**KIRKLEES METROPOLITAN COUNCIL
INVESTMENT & REGENERATION SERVICE**

Reference No:	2022/60/92783/E
Site Address:	60, Carr Hill Road, Upper Cumberworth, Huddersfield, HD8 8XN
Description:	Outline application for demolition of existing dwelling and erection of two dwellings with detached garages
Recommending Officer:	Callum Harrison

Officer Report

2022/92783 - 60, Carr Hill Road, Upper Cumberworth, Huddersfield, HD8 8XN

client	Mr. L. & Mrs. J. BENTLEY		
project	PROPOSED CONSTRUCTION OF TWO NEW DWELLINGS		
address	60 CARR HILL ROAD UPPER CUMBERWORTH HUDDERSFIELD HD8 8XN		
drawing title	SITE PLAN AS PROPOSED		
scale	1:500 @ A3	prefix	2022.09
drawing No	(B) SP 02	rev

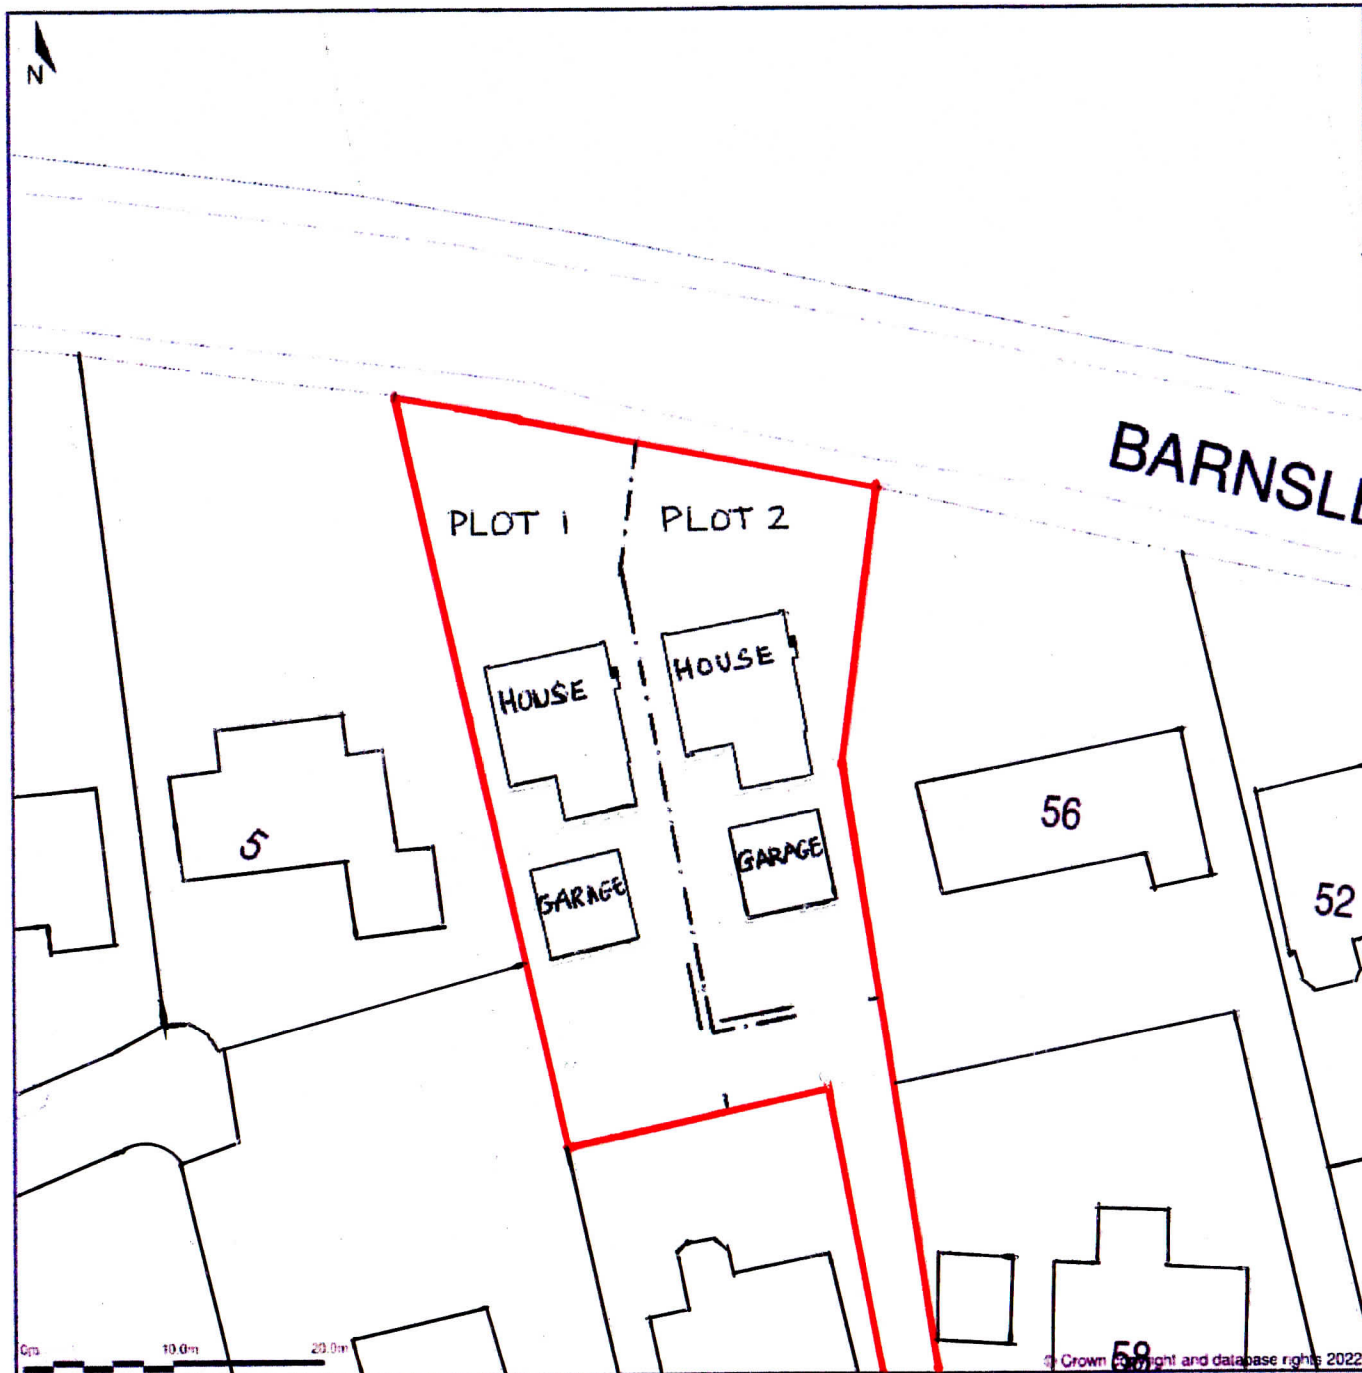
The application is seeking an outline permission for demolition of existing dwelling and erection of two dwellings with detached garages, with all matters reserved. The indicative site plan submitted shows two dwellings set parallel within the plot, with garages to the front (south). There is no indication of the potential number of storeys of each dwelling however the application indicates each dwelling would have four bedrooms. The indicative site plan shows the main garden areas to the north and the two dwellings to share the existing access.

The application site comprises of a good sized plot surrounded by residential dwellings to the west, south and east. A Classified A road bounds the site to the north. On this thread of development on the north side of Carr Hill Road between Carr Mount and the triangle where Carr Hill Road forks three ways, there is a clear character to the properties. All of the properties are of a similar size with regard to footprint and set within similar sized plots. The clear character is also prevalent along the southern side of Carr Hill Road. There are also two parallel build lines formed when the dwellings fronting on to Carr Hill Road were built in the 1990s. To erect two dwelling within the existing plot would create two plots substantially smaller than any of the neighbouring plots. To build two dwellings within the existing build line which is required by Principle 5 of the Housebuilders Design Guide, the plot would have to be split from ‘vertically’ from north to south as shown on the indicative site plan. If the plot were to be split to provide two dwelling, the form and layout of the site would no longer complement the surrounding built form and would not fit in with the coherent identity of the form of the immediate vicinity and result in an inappropriate spatial relationship with other dwellings. The splitting of this plot for two dwellings would without doubt detriment the amenity of the area visually and would negatively impact upon the sense of place and character of the street.

Thus, officers consider the subdivision of the plot would result in development that does not respect the current form and character of the immediate area. The principal of providing two dwellings on this plot does not take cues from the character of the built environment within the locality. The development also would not create a positive and coherent identity nor complementing the surrounding built form in terms of its form.

The positioning of the garages and increase in built form further exacerbates concerns regarding the poor layout and form. Whilst indicative at this stage the poor relationship formed with the host building is not something that could be supported.

As such, the proposed development would result in an inappropriate spatial relationship with the townscape and is considered contrary to Principle 5 of

the Housebuilders Design Guide. With relation to Local Plan Policy LP24 and Chapter 12 of the NPPF directly, for the aforementioned reasons, the development would also fail to enhance the character of the townscape, contrary to these policies.

With regard to highway safety, the access would remain as existing. Whilst guidance recommends that the access should be widened to a minimum of 4.5m for the first 5m of the access road to allow for two vehicles to pass each other this is clearly not achievable. In this instance there are mitigating factors. This application is for only one additional dwelling on the site and access is from an unclassified estate road, as such the minimal increase in the number of vehicles that would be expected to use the access cannot be considered detrimental to highway safety as such, not meeting the threshold to refuse an application on highways safety grounds as set out by Paragraph 111 of the NPPF.

With regard to internal layout, including parking revision, these are matters that would be assessed at the reserve matters stage. Officers note KC Highways Development Management’s concerns with the indicative layout and insufficient information, however as this application is for outline permission with all matters reserved, internal layout cannot yet be assessed. KC Highways Development Management have no objections to the matters that can be assessed at this stage. As such considering all matters are reserved, the scheme is considered acceptable with regard to highway safety at this stage. At the reserved matters stage, the following information would be required:

- A swept path analysis to show that a Kirklees fire service vehicle can both access and turn within the site, in the case of an emergency, needs to be provided.
- A layout plan showing the location of the proposed parking spaces and swept path analysis to show that the vehicles can turn to leave the site in forward gear needs to be provided.
- Details of waste storage and collection for both dwellings should be provided, with the location of a waste collection presentation point being clearly marked on a drawing.

1. The proposed development, in subdividing the existing plot to two smaller plots with ancillary garage and curtilage, results in a built form out of keeping with spacious plots within the street, resulting in an inappropriate spatial relationship within the wider area which would detract from the prevailing development pattern and established character. To permit the development in its current form would be contrary to Policy LP24 of the Kirklees Local Plan, Principle 5 of the Housebuilders Design Guide Supplementary Planning Document and Chapter 12 of the National Planning Policy Framework.
